**Consultation Response from KC,
Highways Development Management**

2024/93336 209, Scar Lane, Milnsbridge, Huddersfield, HD3 4PZ

**Erection of detached building to create dwelling forming annex accommodation associated
with 209, Scar Lane, Milnsbridge, Huddersfield, HD3 4PZ**

Date Responded: 28/01/2025

TITLE: **Site and Ground Floor Plan**
As Proposed

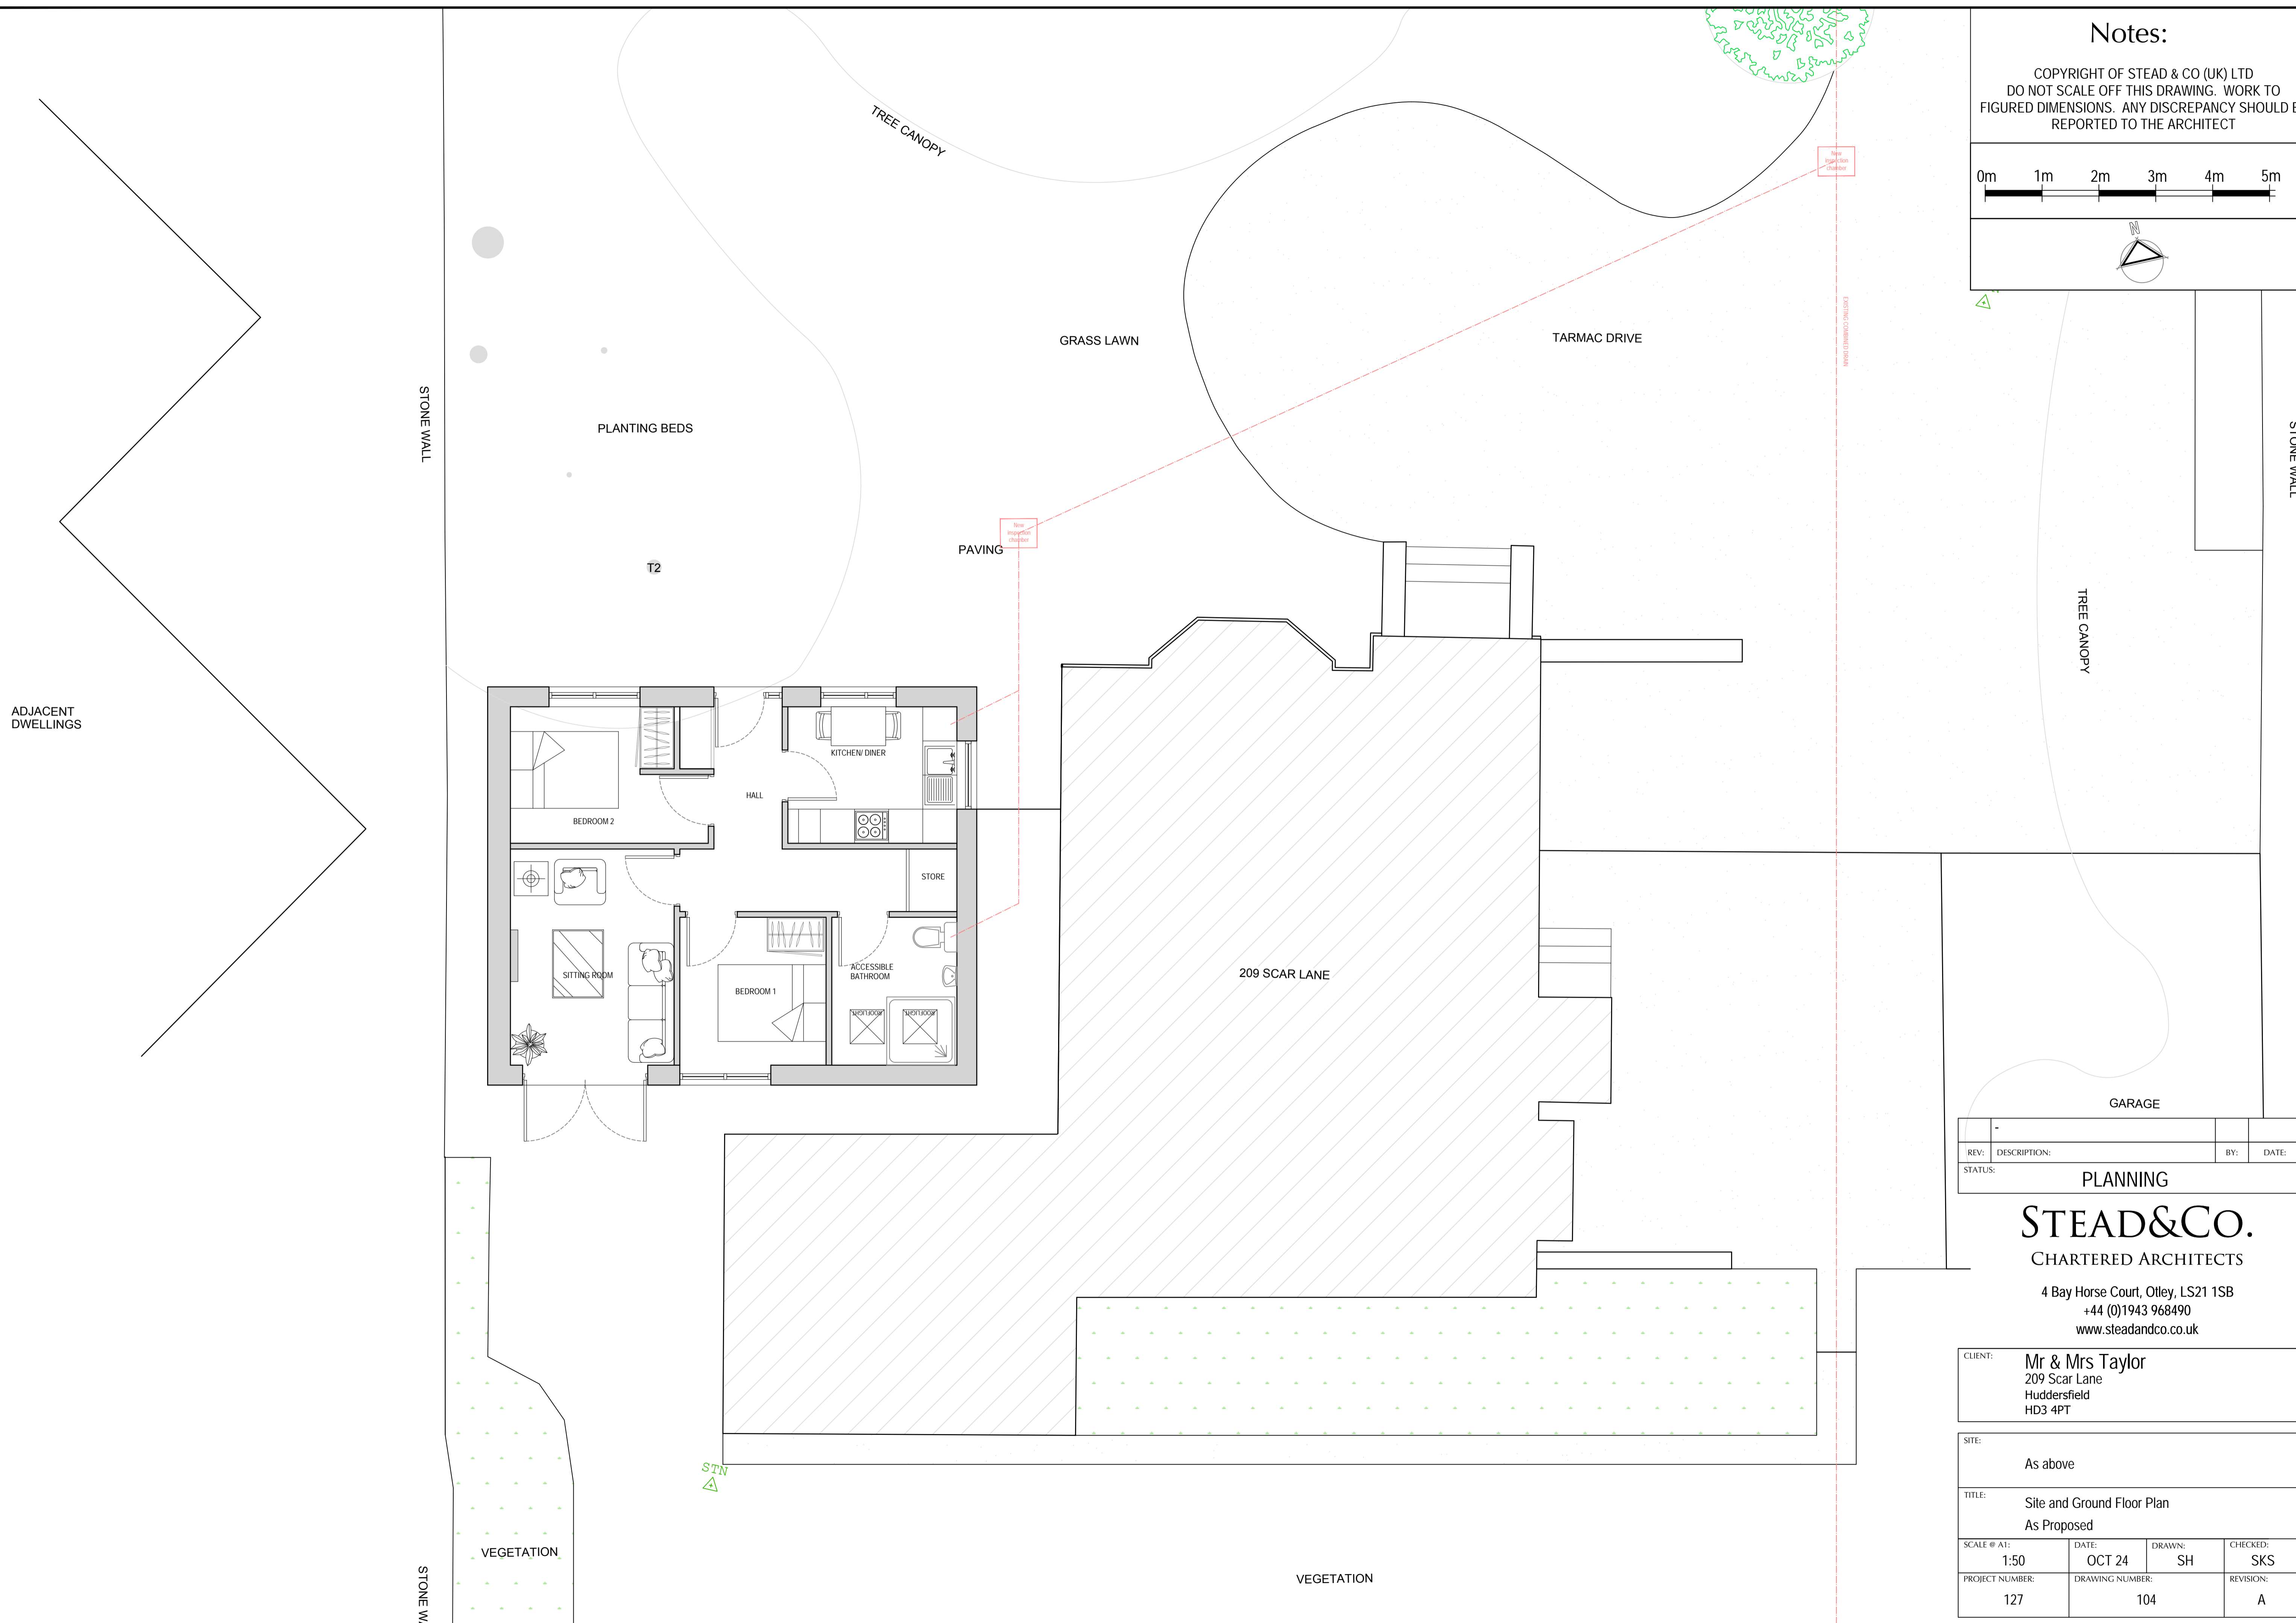
The access to the site is from the fourth arm of a mini roundabout at the junction of B6111 Scar Lane and Tintern Avenue and because of this we would not wish to support any development that causes a noticeable intensification of use of the access. As a detached 2-bed annexe to the existing dwelling at 209 Scar Lane we would not expect the proposal site to generate sufficient trips as to have an adverse impact at the junction. To maintain this level of trip generation we would request that a condition is put in place to keep the proposed building annexed to the existing dwelling and not to be rented commercially.

No parking is to be provided with the proposal building, however there is parking associated with the existing dwelling and any additional parking demand created by the proposals should be able to be accommodated within the existing car parking area without obstructing any turning areas.

The development hereby approved shall be used as annexe accommodation by the owner / occupier of No 209 Scar Lane for their private use only and shall not be used for commercial purposes or sold or rented out separately.
